Application No: R/171/21/HH
Site Address: 2 Windmill Drive Rustington BN16 3HJ
Description of works: Erection of a gazebo and hip to gable loft conversion including a change of boundary treatment

My Council has considered this application and wishes to object to it on the following grounds:-

GAZEBO FRONT ELEVATION (NORTH)

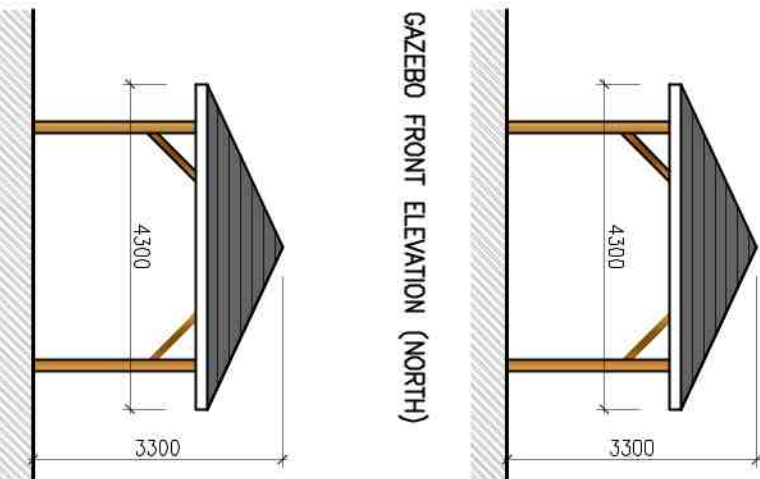
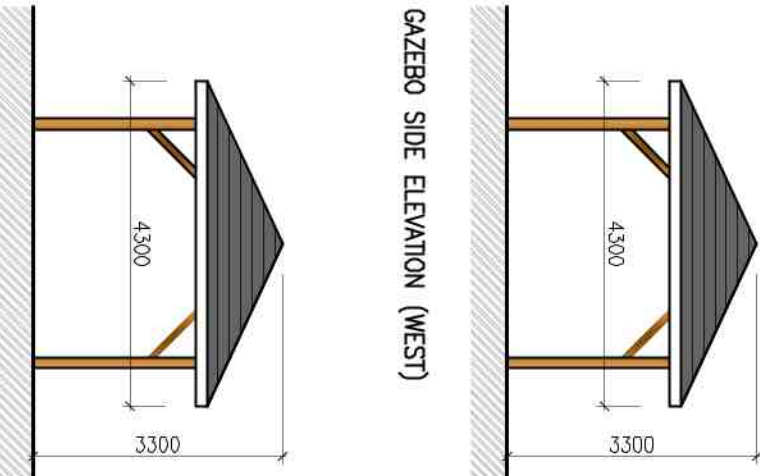
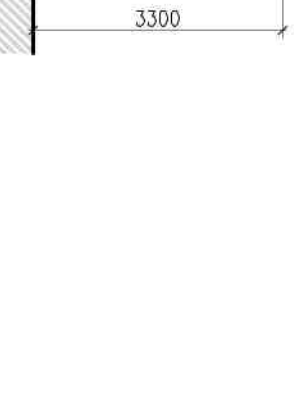
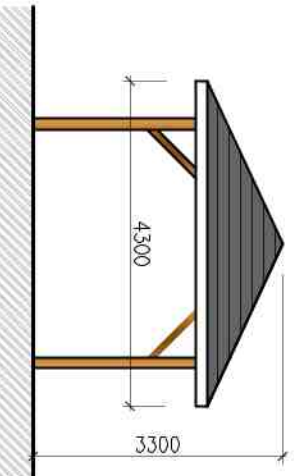
- (i) The proposal to erect a gazebo, in extremely close proximity to the boundary with the adjacent property Number 22 Orchard Gardens, with a maximum height of over 3 metres will, by reason of its height, present an over-bearing appearance, which would have a detrimental effect on the visual amenities and quiet enjoyment of the aforementioned property
- (ii) The proposal for this gazebo would, most definitely, be in conflict with the Arun District Council Planning Permissions - Outbuildings, which states that outbuildings should not be any higher than 2.5 metres to the eaves, if closer than 2 metres to the boundary.
